City of Portland, Maine – Building or Use Permit Application 389 Congress Street, 04101, Tel: (207) 874-8703, FAX: 874-8716

**Minor/Minor Site Review for New Detached Single Family Dwelling,
Additions/Alterations/Accessory Structures, Multi-Family, Commercial Interior Rehab
(other than additions), Change of Use**

BUILDING PERMIT REPORT

**CITY OF PORTLAND, ME
BOCA 1999 Plan Review Record
One and Two Family Dwelling**

'GATE HOUSE'

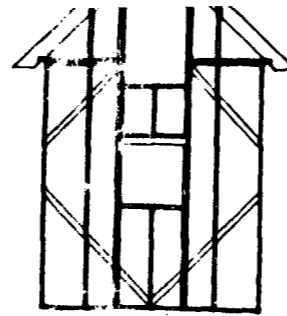
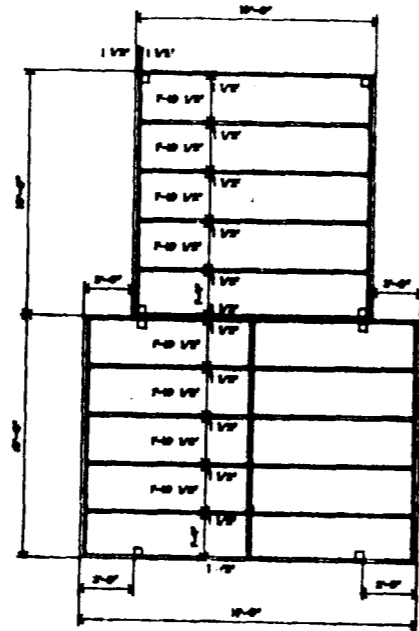
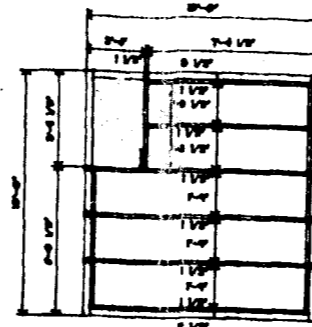
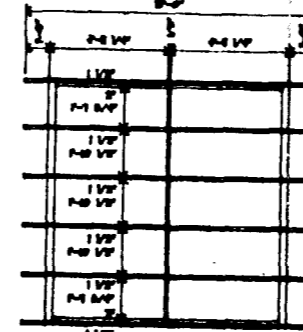
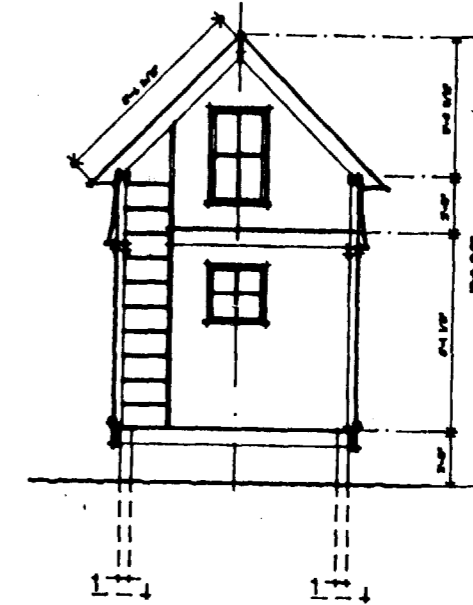
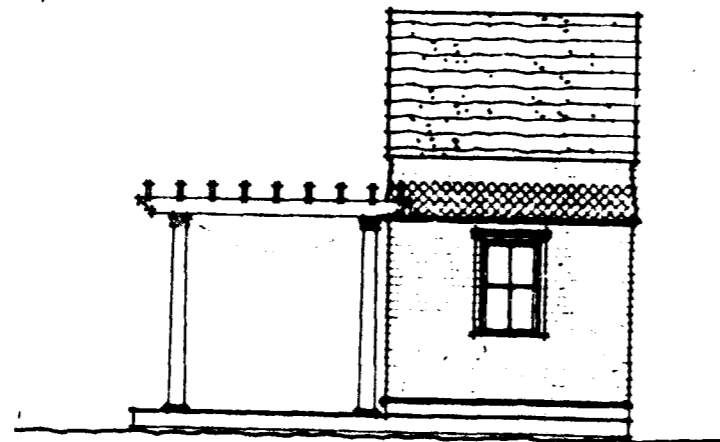
No Kitchen
 No Plumbing
 No elec.
 30' setback
 Shown

→ conditions "Gate House" shall not have any kitchen facilities

FIRST FLOOR PLAN

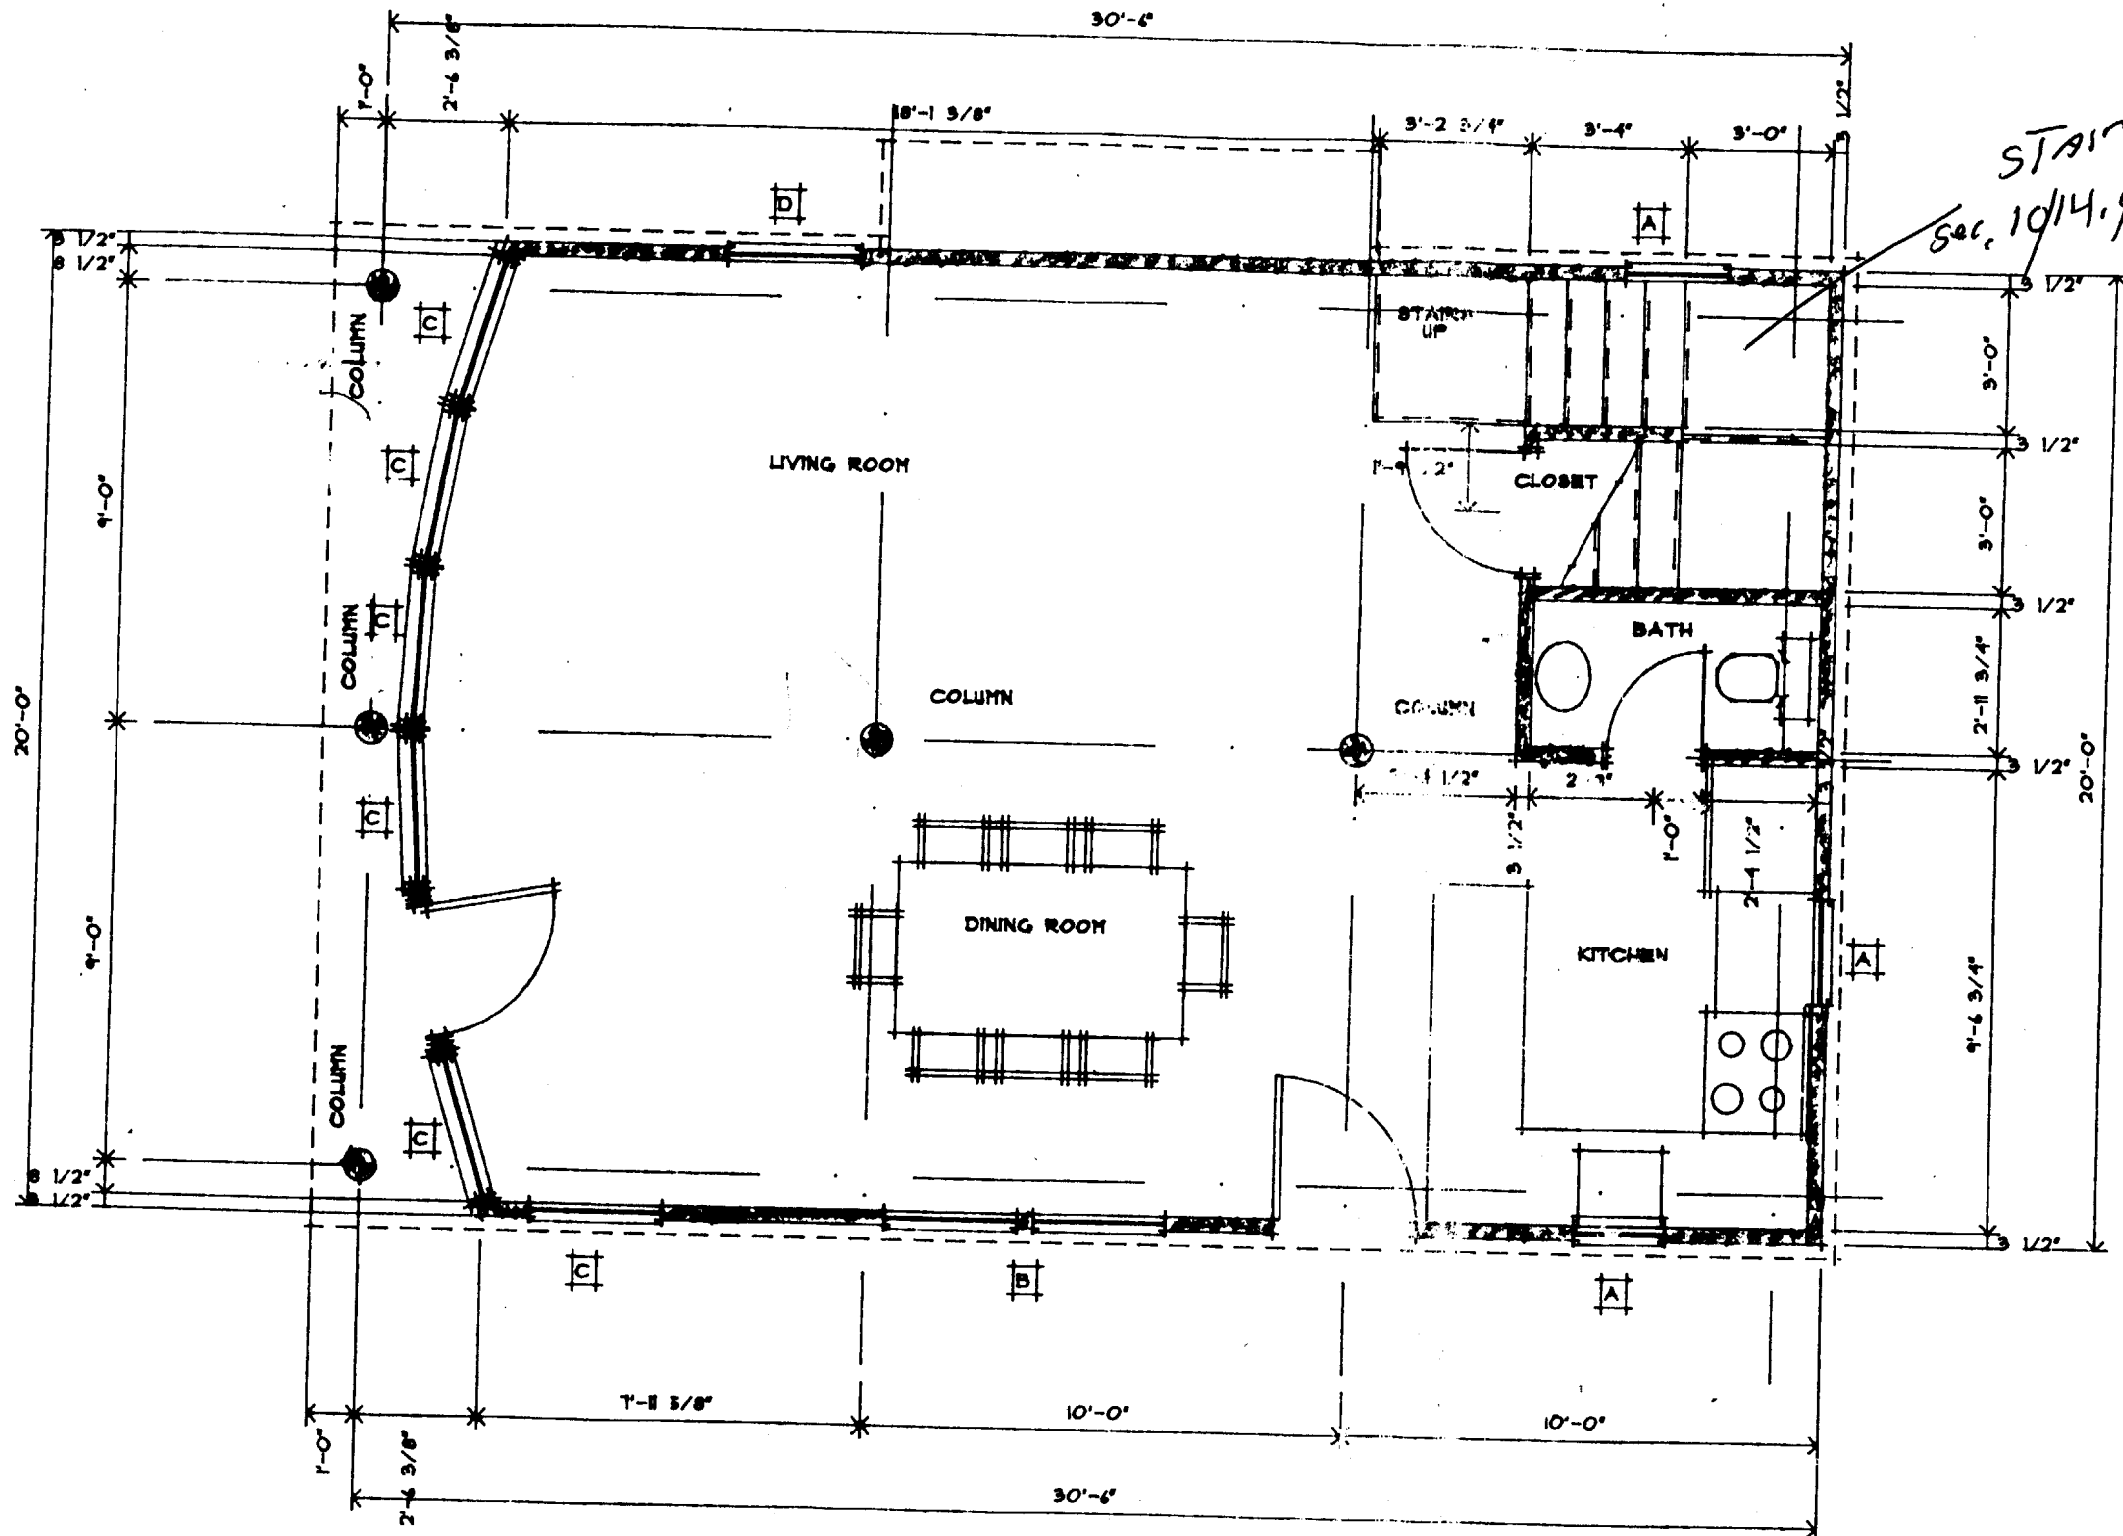
4.	Chimneys and vents shall comply with NFPA 211	NFPA 211
5.	Stair construction shall comply with section 1014.0 (see attachment)	1014.0
6.	Guardrails and handrails shall comply with sections 1021.0 - 1022.0	1021.0 1022.0
